**RFI**

**RFI #: 218**  
**Date:** 2/11/2013  
**Job:** EB-02 Keller Springs Lofts  
**Phone:** 877-777-5115

**Subject:** Door Mark #30 in A4 Alt F unit # 1167

2.0A

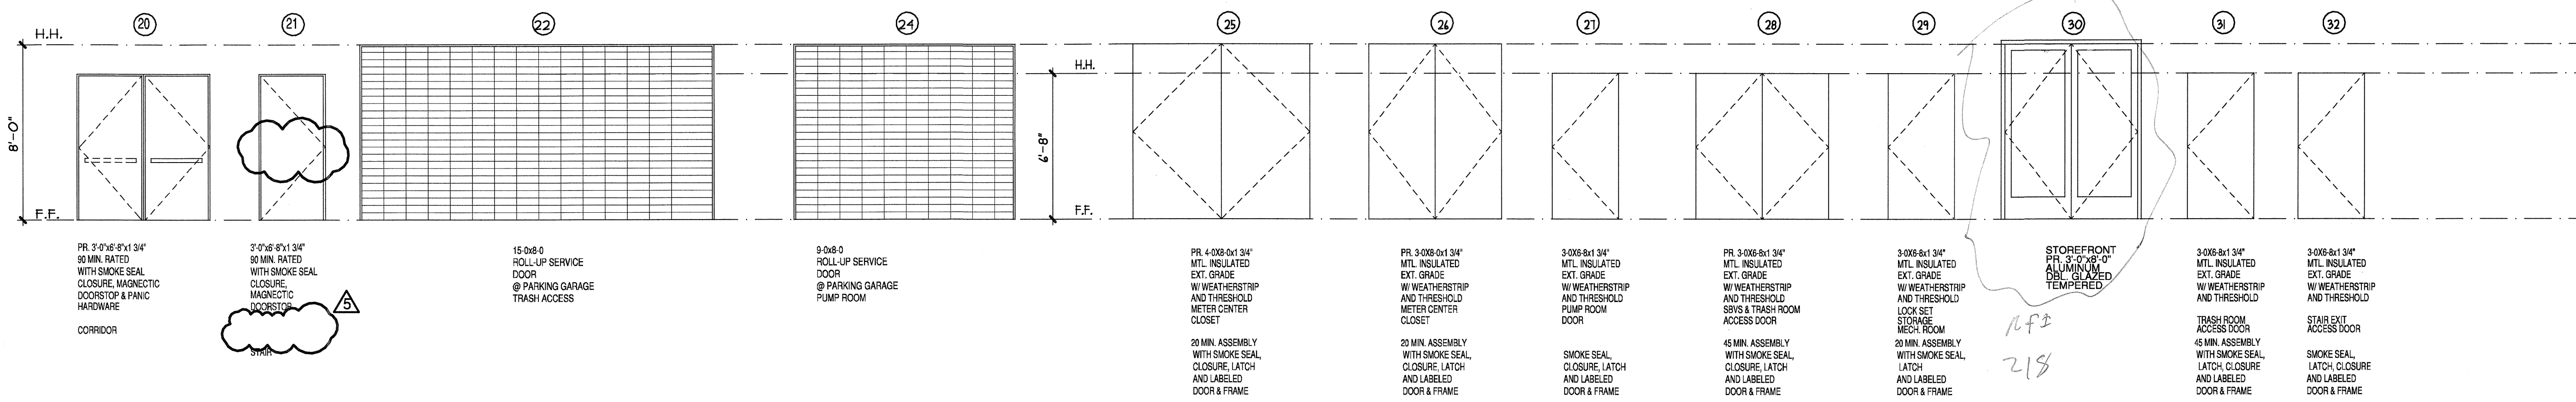
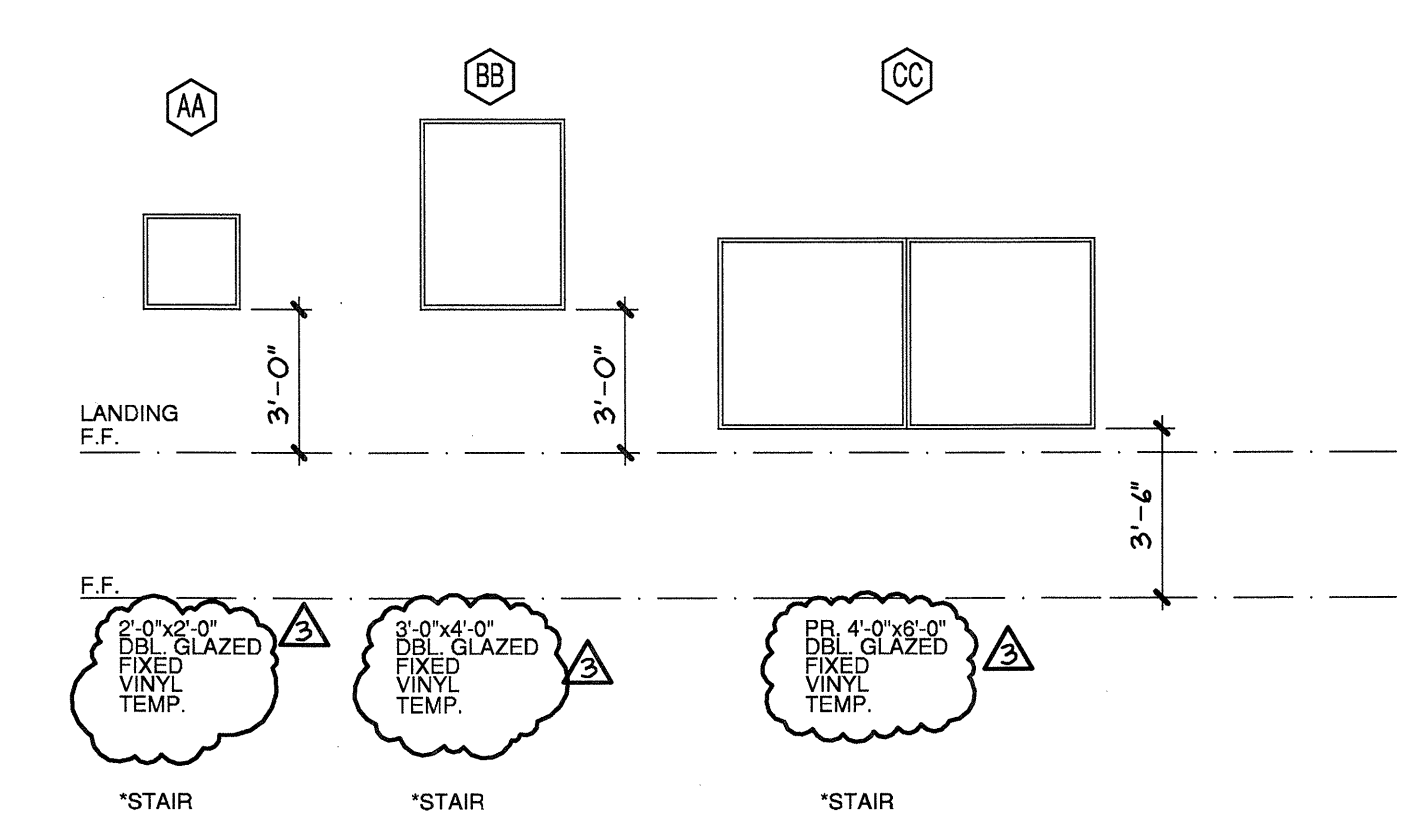
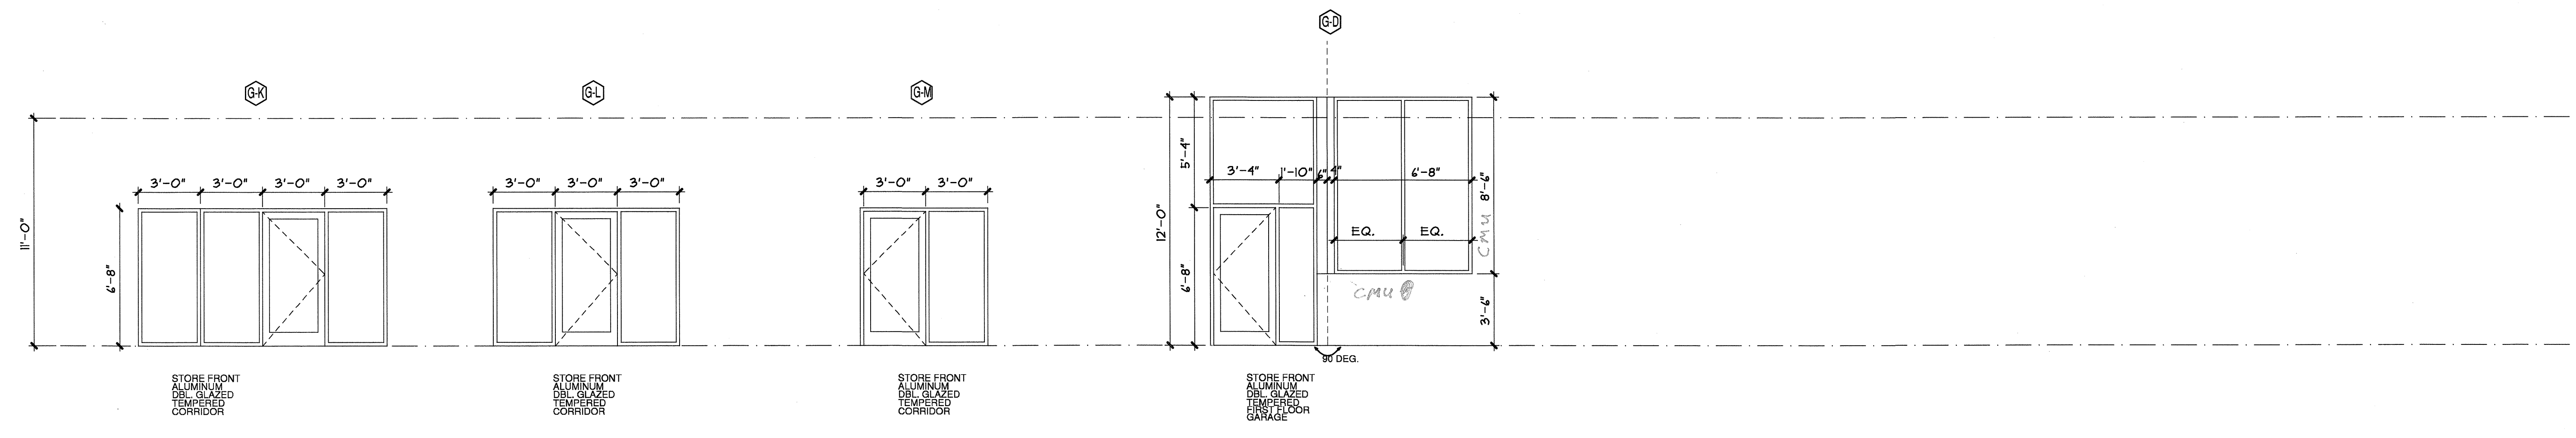
**Request:** **Date Required:** 2/15/2013  
In section #7 unit #1167 which is the only A4 Alt F unit on the project, the plans show a door mark #30 which on sheet 2.0A shows it being a pair of 3'-8" storefront. There has been discussion on changing this to a typical unit exterior French door which would be a pair of 3'-6" with one operable right hand door with the other being a fixed light panel. By doing this, the door would match the appearance of adjoining, and all other exterior French doors.

**Response:**  
Yes please provide a French door to match other balcony doors.
